Rampion 2 Offshore Wind Farm (Project Reference: EN010117)
Principal Areas of Disagreement Statement (PADS) – Version 2
West Sussex County Council
August 2024

This statement has been prepared by West Sussex County Council (WSCC). WSCC is a host authority for the Rampion 2 Offshore Wind Farm DCO, which was accepted on 20 September 2023 by the Planning Inspectorate for Examination. This document identifies the principal areas of disagreement that remain at the close of the Examination, which commenced on 6 February 2024. Version 2 of this statement removes those areas of principal disagreement that have now been satisfied through either engagement with the Applicant or through the provision of information provided by the Applicant through the Examination.

OAKENDENE SUBSTATION INDICATIVE LANDSCAPE PLAN

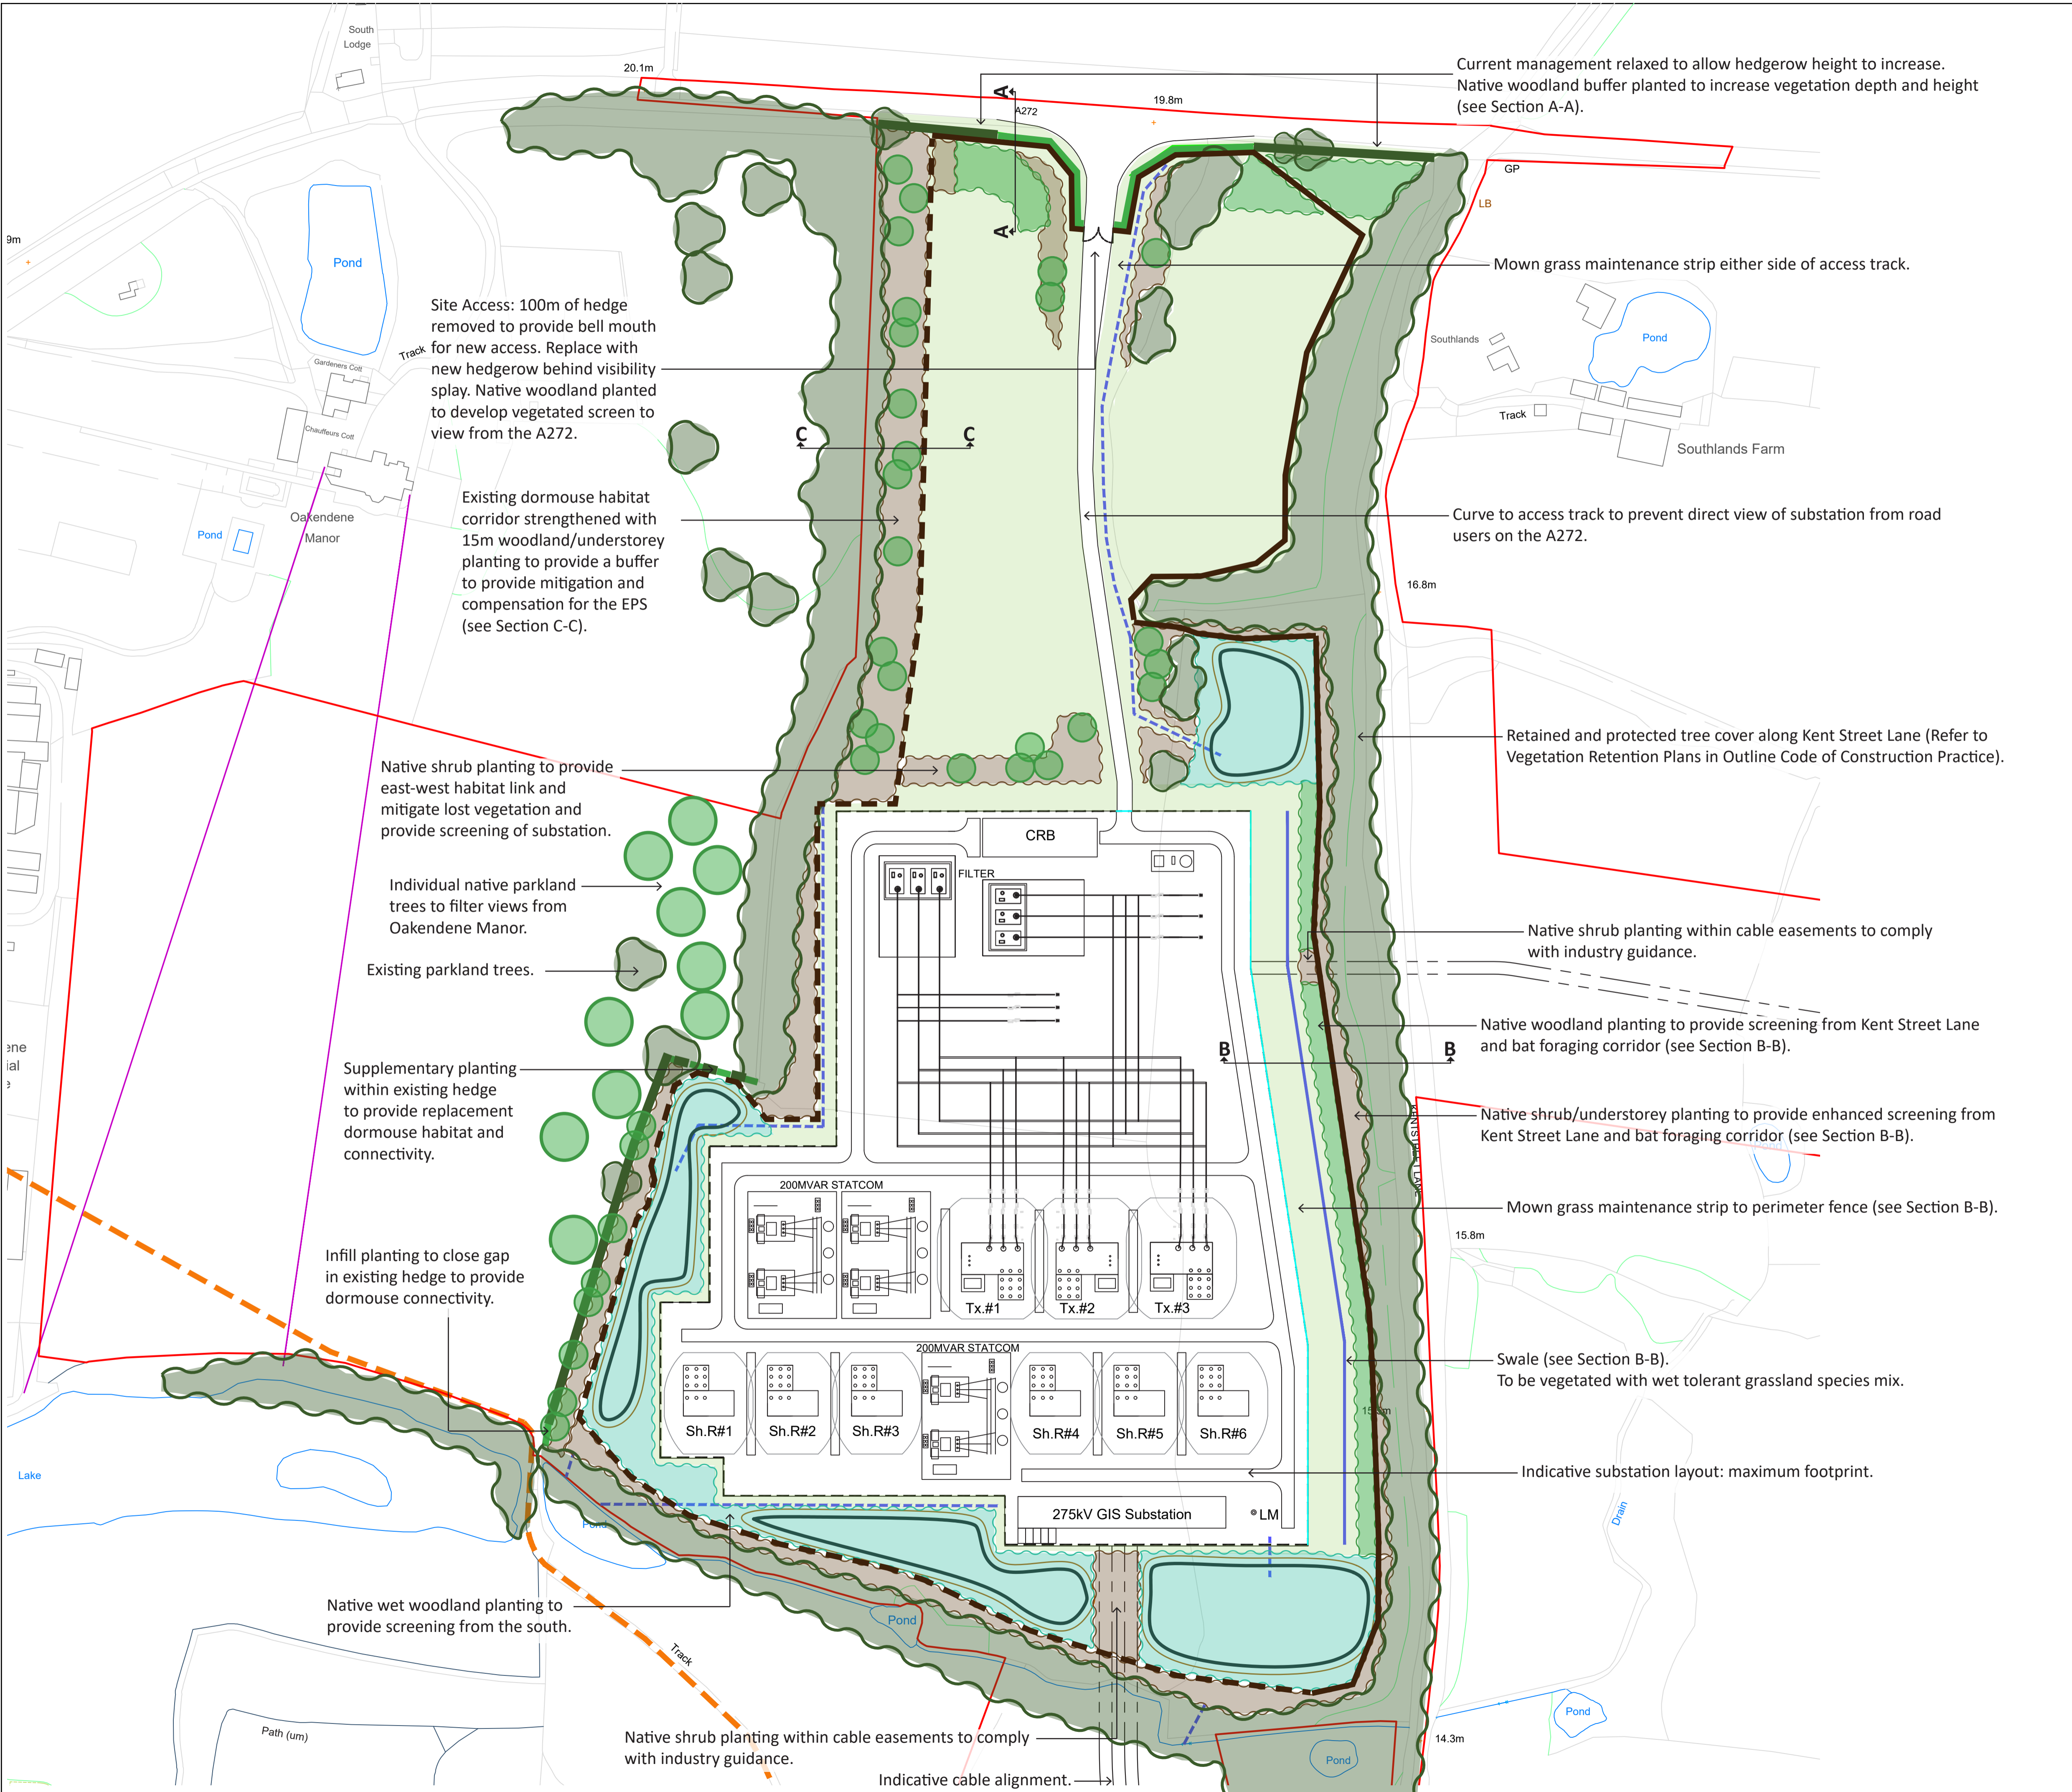
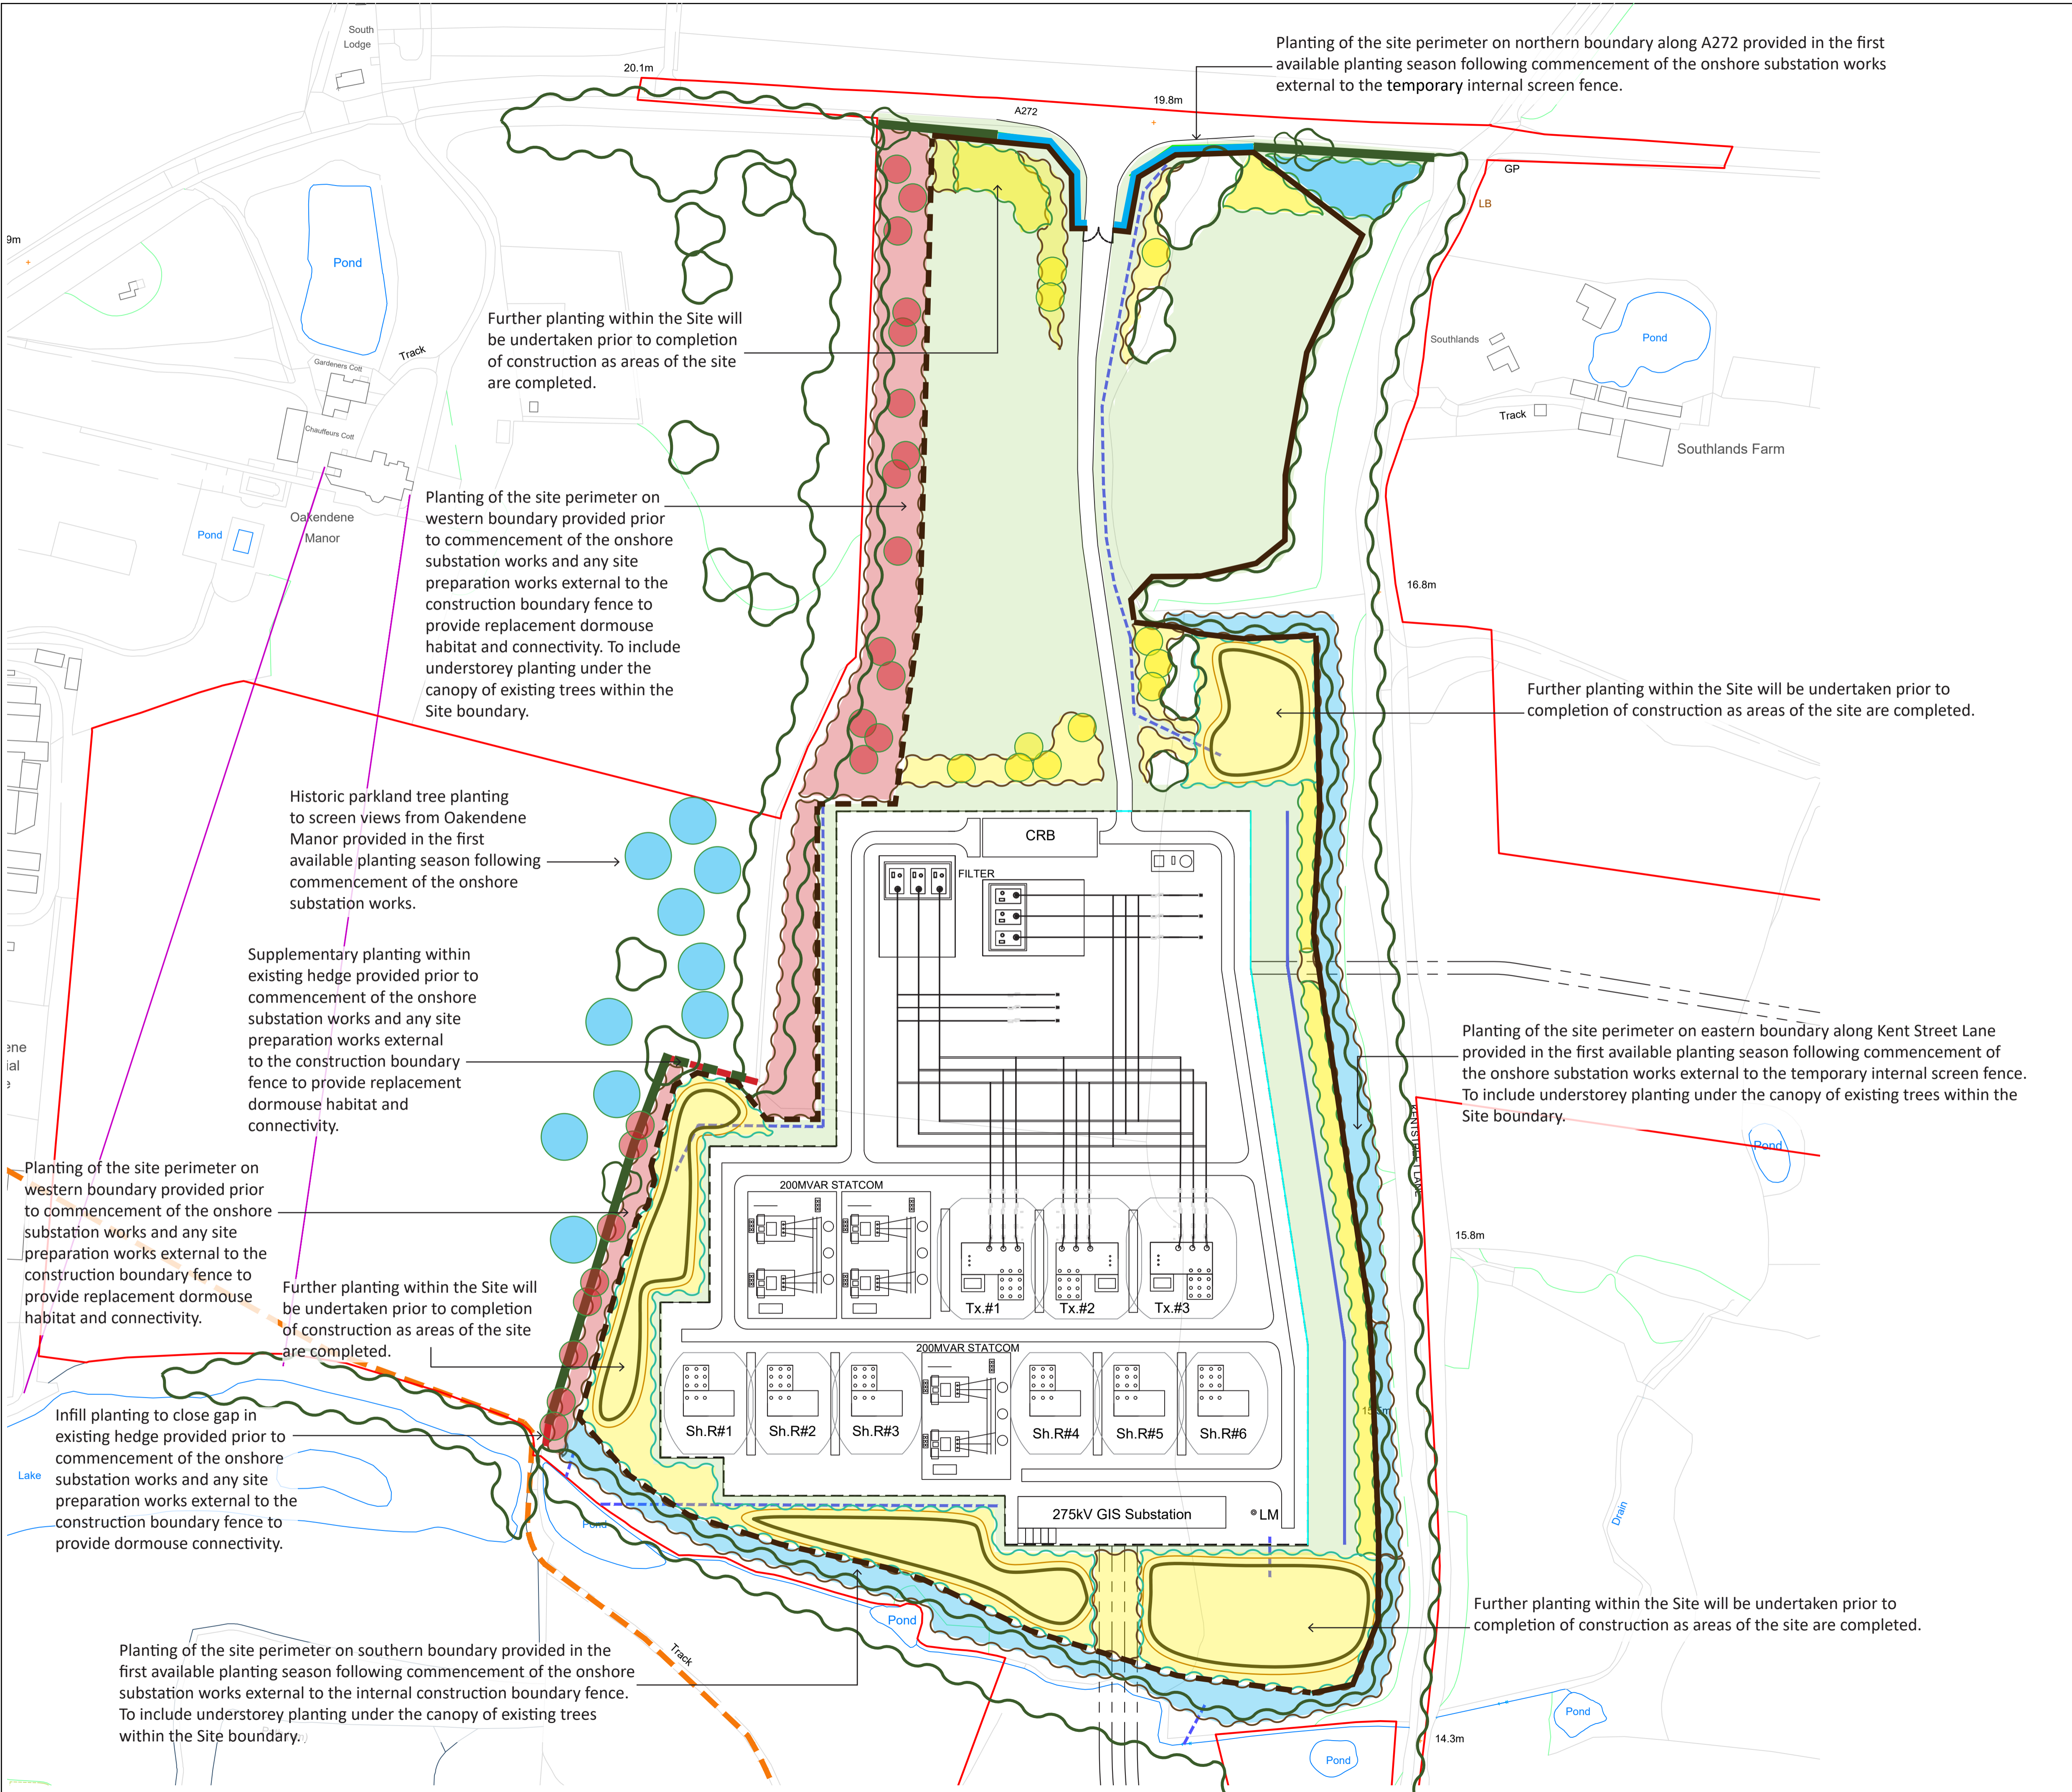
| Ref | Principal Issue in Question | Concern held | What needs to change/be amended/be included in order to satisfactorily address the concern |
|-----|--|---|--|
| 12. | Effects of proposals upon grade II listed Oakendene Manor (NHLE 1027074) | <p>WSCC is concerned about the proposed harm to grade II listed Oakendene manor, arising via changes within its setting from construction and operation of Oakendene substation and compounds.</p> <p>WSCC welcomes the additional viewpoint photography provided by the Applicant, and considers the assessment is now appropriately evidenced. WSCC is now in a position to agree with the overall assessment of a Medium magnitude of adverse change to Oakendene manor.</p> <p>WSCC disagrees with aspects of the narrative assessment of effects on Oakendene Manor within the ES chapter, which downplay the importance of current key views and the predicted degree of change to these views during and following construction of the substation. This gives a misleading impression of the true magnitude of change to the setting</p> | WSCC requests the Applicant provide an updated, more detailed and nuanced assessment to evidence their conclusion of less than substantial harm. This should be based on the specific impacts of the predicted changes to the asset’s architectural and historic interest and overall significance. And not solely on equating a Medium adverse magnitude of change in EIA terms, to less than substantial harm. |

| Ref | Principal Issue in Question | Concern held | What needs to change/be amended/be included in order to satisfactorily address the concern |
|--|---|---|---|
| | | <p>of Oakendene, and the degree to which the ability to appreciate significance will be reduced. Please see WSCC Deadline 5 submission and WSCC’s response to the ExA’s Further Written Question HE 2.1 for further detail.</p> <p>WSCC also disagrees with the methodology employed for assessing substantial, versus less than substantial harm. Please see WSCC Deadline 5 submission and WSCC’s response to the ExA’s Further Written Question HE 2.1 for further detail.</p> | |
